The Secretary

7th October 2025

Re: ACP-322958-25 Athlone Link Road Phase 2 – Westmeath County Council response to submissions received by An Coimisiún Pleanála

Drawing file: Drawings / 120278-5001 PL1 Vegetation to be Removed.pdf

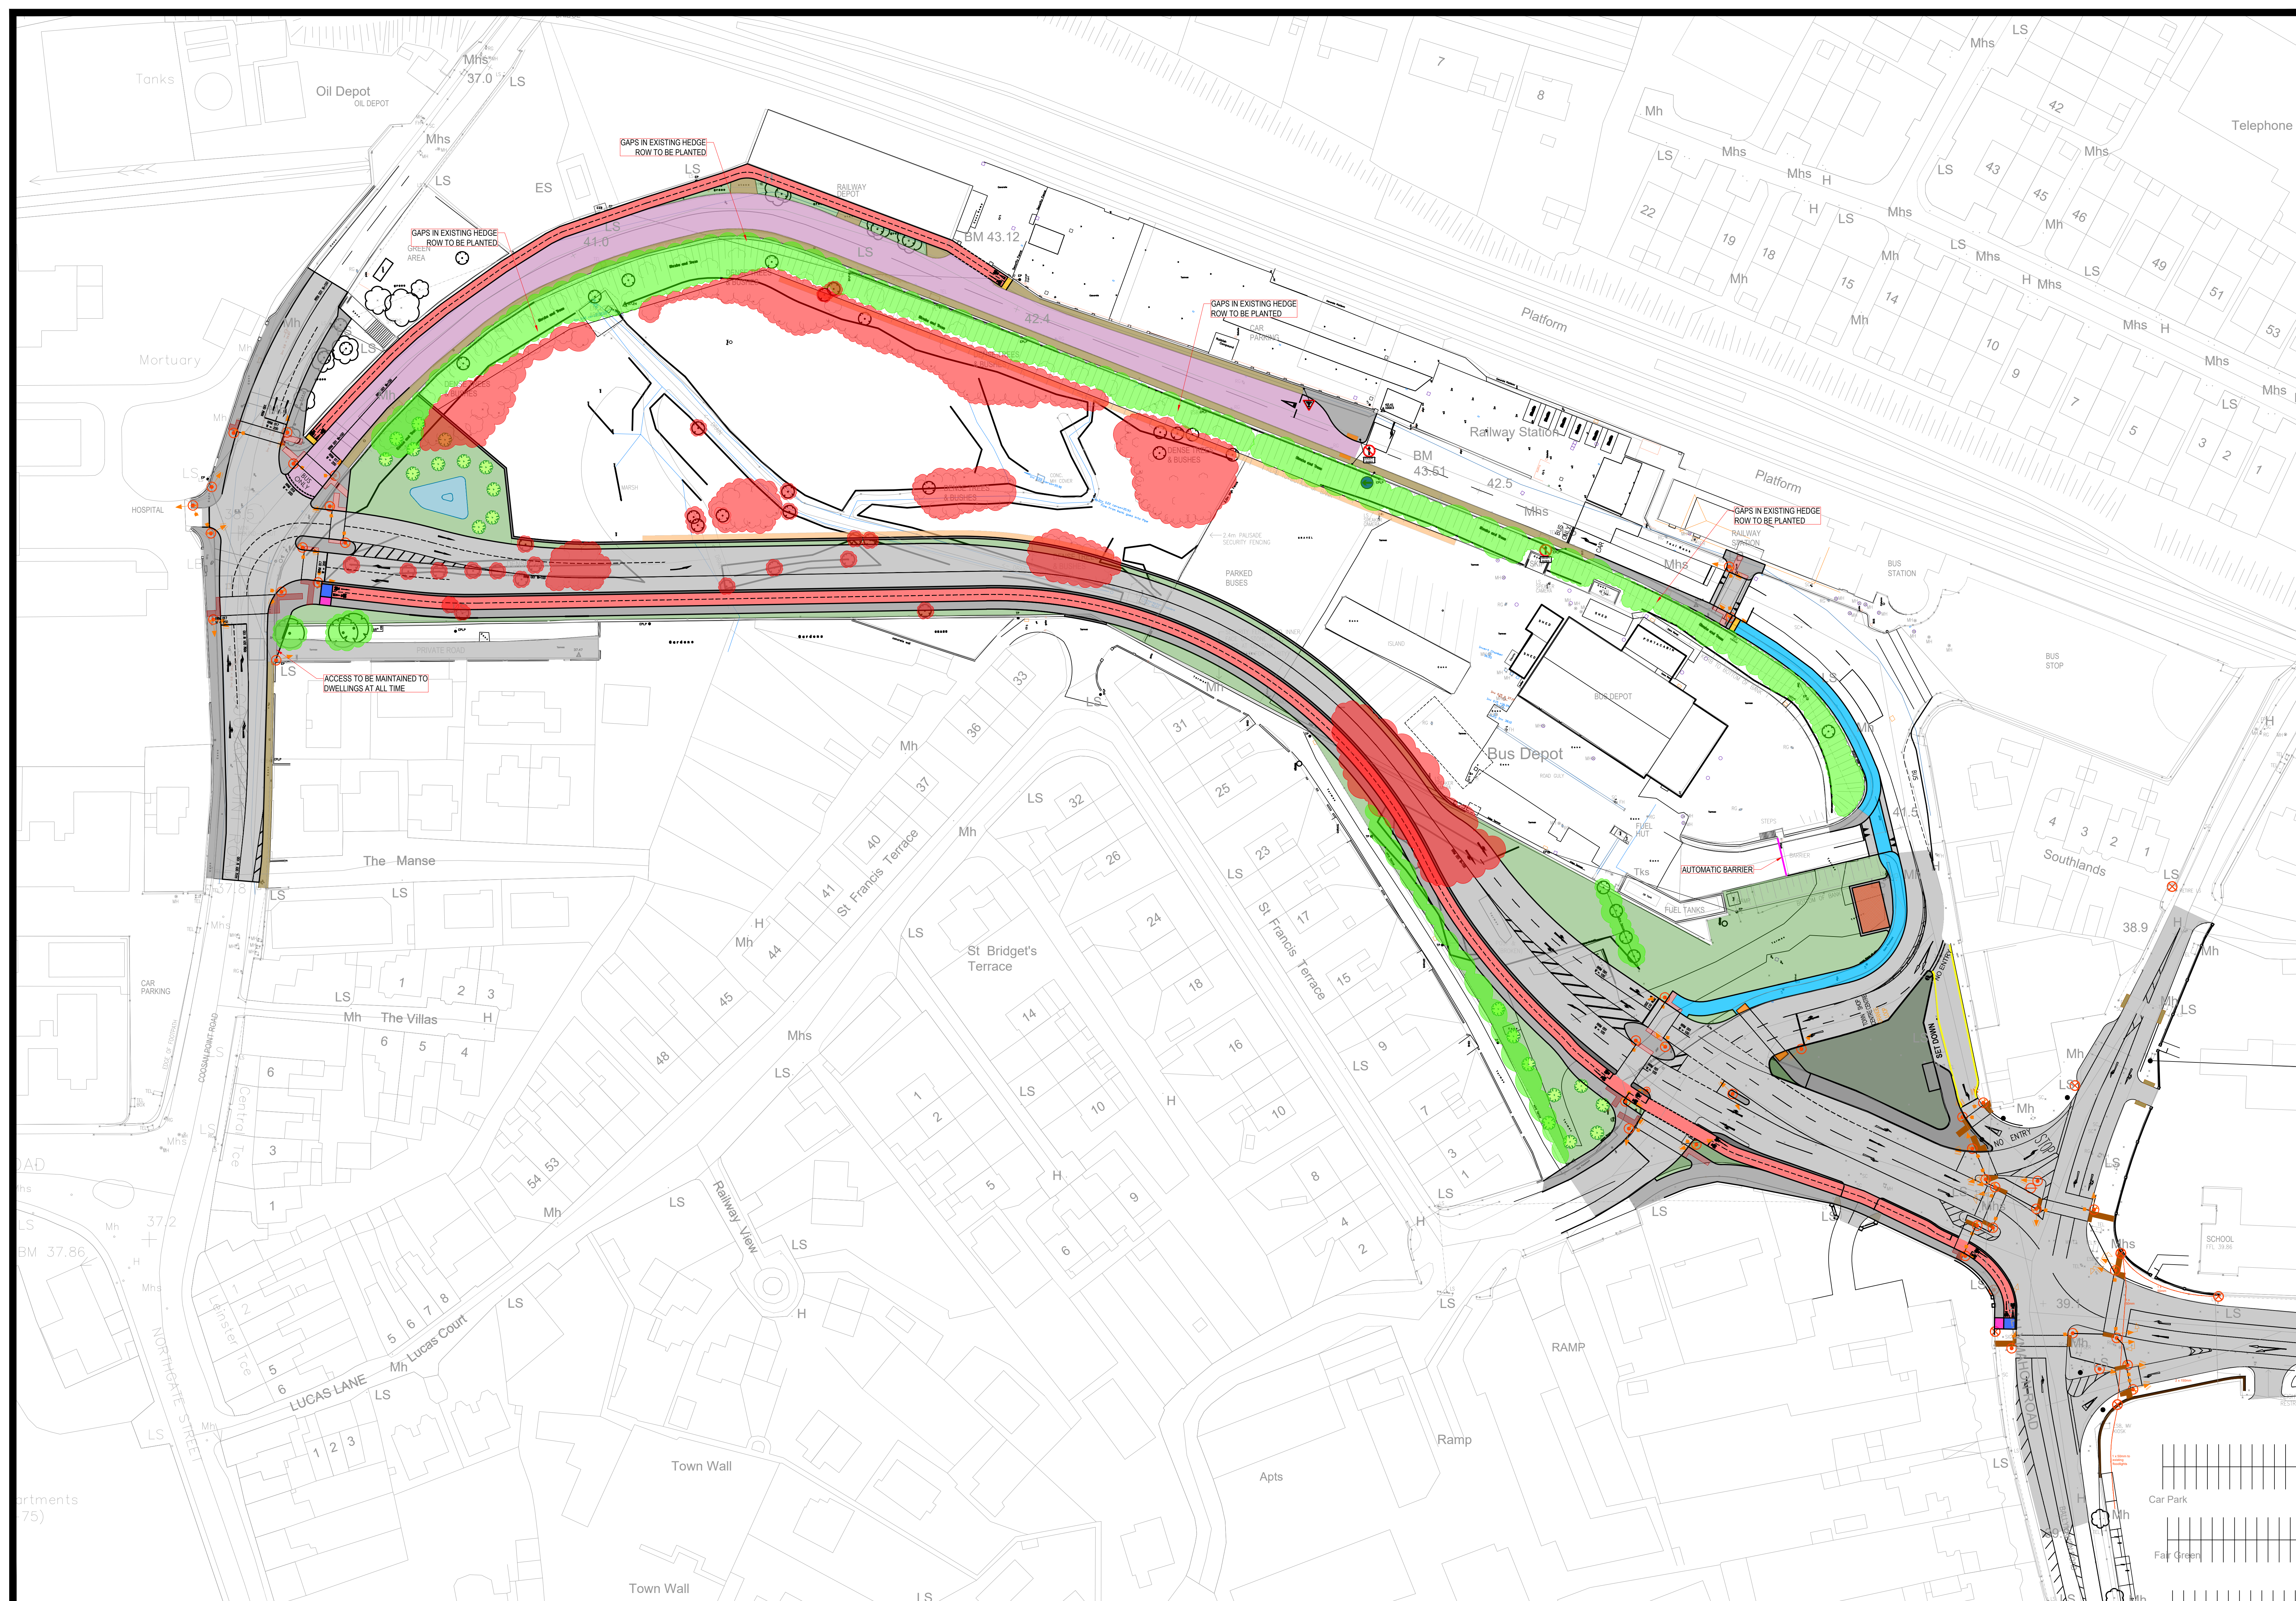
3G Concern raised	“That Vegetation to be removed drawing number 120278-5001 is not accurate. The document omits a significant number of trees and bushes [that include] native Irish hardwood species.”
WCC response to 3G	Coiscéim Consulting Ecologists have dealt with the matter within the EcIA report.
3H Issue raised	“Trees to be removed to construct a boundary wall.
WCC response to 3H	While every effort has been taken to minimize the number of trees that will need to be removed to construct the proposed development, some the trees located along the boundary wall will need to be removed to facilitate the construction of this boundary wall. It is proposed to plant new trees along the boundary, green areas and around the biodiversity pond on the west of the site.
3I Request raised	“Request for boundary wall height to be increased to 2.4m”
WCC response to 3I	While selecting a height for the boundary wall, the design team has made every effort to preserve residents’ privacy and sense of security during the design process, while trying to balance this against creating a new streetscape that is not hostile to pedestrians and cyclists (especially after dark) and does not encourage speeding, as outlined on page 22 of the Design Manual for Urban Roads and Streets (DMURS). It was based on the above rationale that a wall height of 1.53m was selected.

Concern 5A	“Vegetation to be removed drawing number 120278-5001 is not accurate.”
WCC response to 5A	Coiscéim Consulting’s Ecologist has dealt with the matter within the Ecological Impact Assessment EclA report.
Concern 5B	“The increase in Bus depot capacity from 13 to 44 buses threatens elevated noise and air pollution near residential areas.”
WCC response to 5B	It is not proposed that the number of buses using this facility will increase and therefore there is not expected to be a negative impact in noise and air quality. The number of proposed bus parking spaces is 44, 20 of which are proposed to be electric bus charging spaces. There are currently up to 53 buses parked within this facility. The proposed reconfiguration of the bus depot is as a result of the location and footprint of the ALRP2.
Concern 5C	“Alternative brownfield locations within Athlone could accommodate the depot with far less environmental impact. The proposal contradicts the Athlone Town Development Plan objective to relocate the bus garage out of the town centre, preserve green spaces, and support sustainable connectivity.”

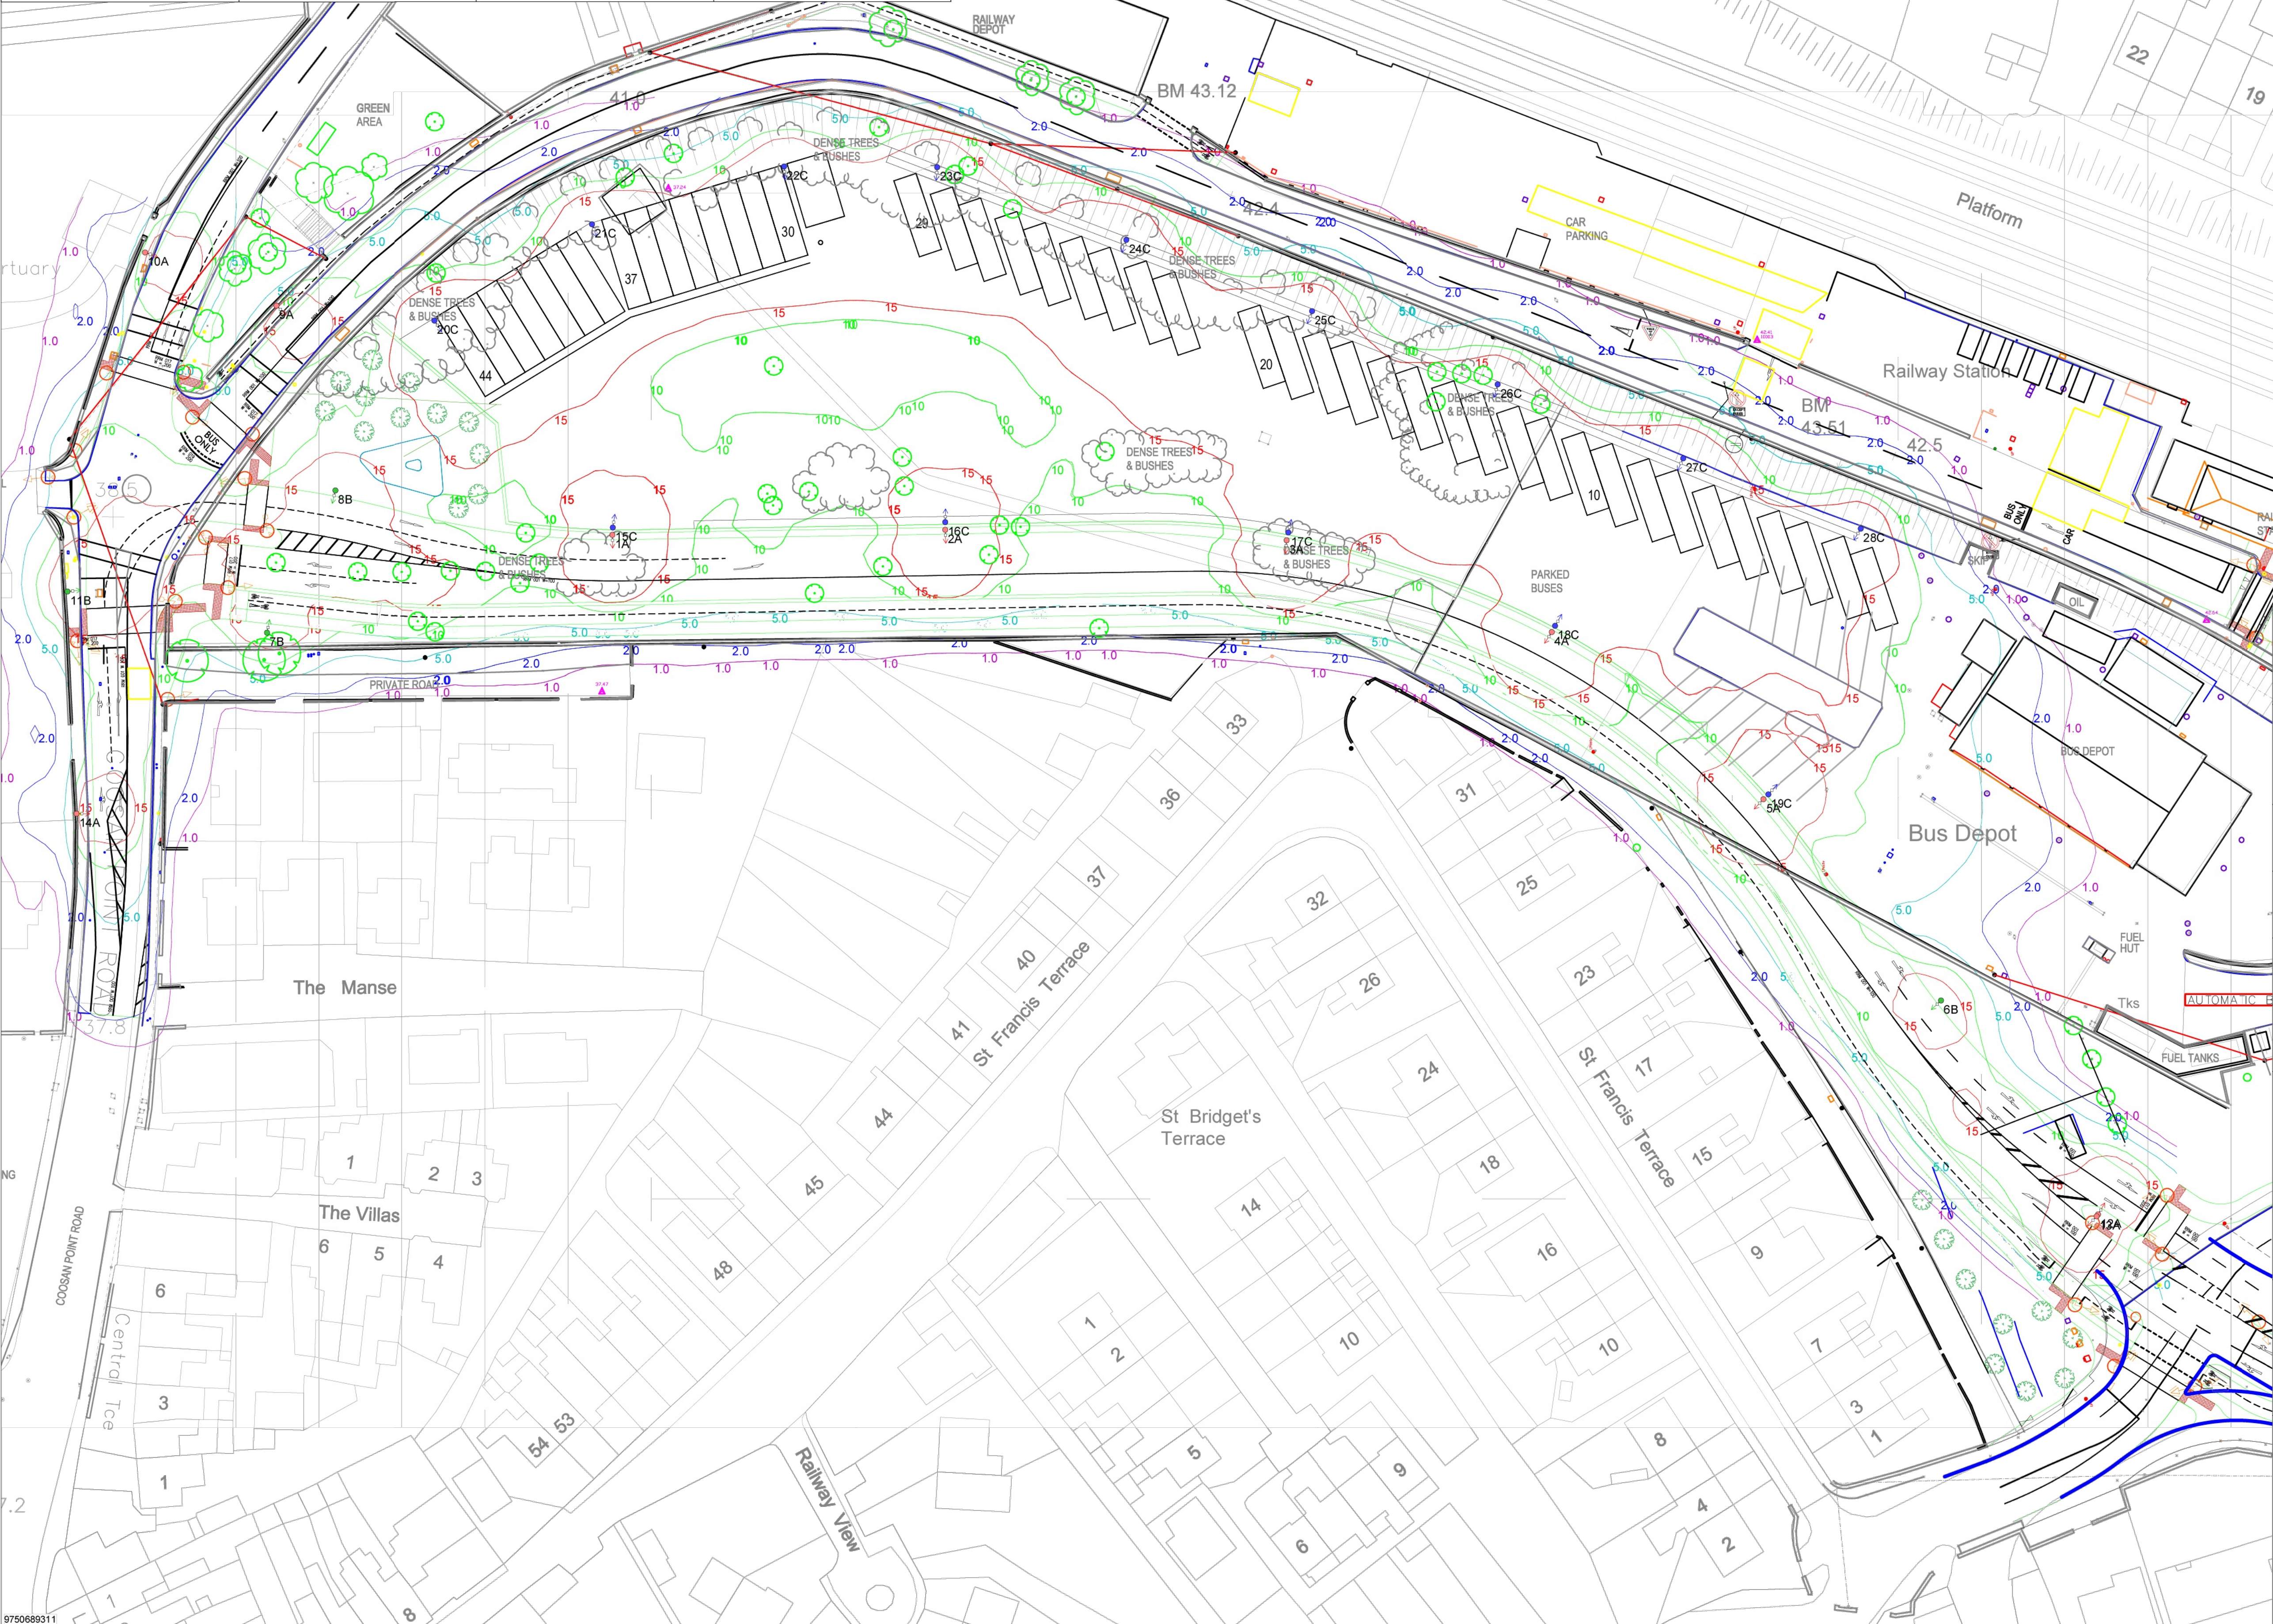
9D Concern raised	"The extra lighting in the area and the proposed 44 Bus bays will be very near my house, I'm concerned about the noise impact and night time sleep for everyone in the area. ie, - noise from buses worked on through the night, near my house."
WCC response to Concern 9D	The lighting design was carried out by Electric Skyline on behalf of WCC, to illustrate that residents will not be impacted by light nuisance as shown by the 1 lumen magenta light line adjacent to The Manse boundary. The inclusion of a boundary wall and a noise reducing surface course pavement such as Stone Mastic Asphalt (SMA) would minimize the traffic noise impact on her dwelling house.
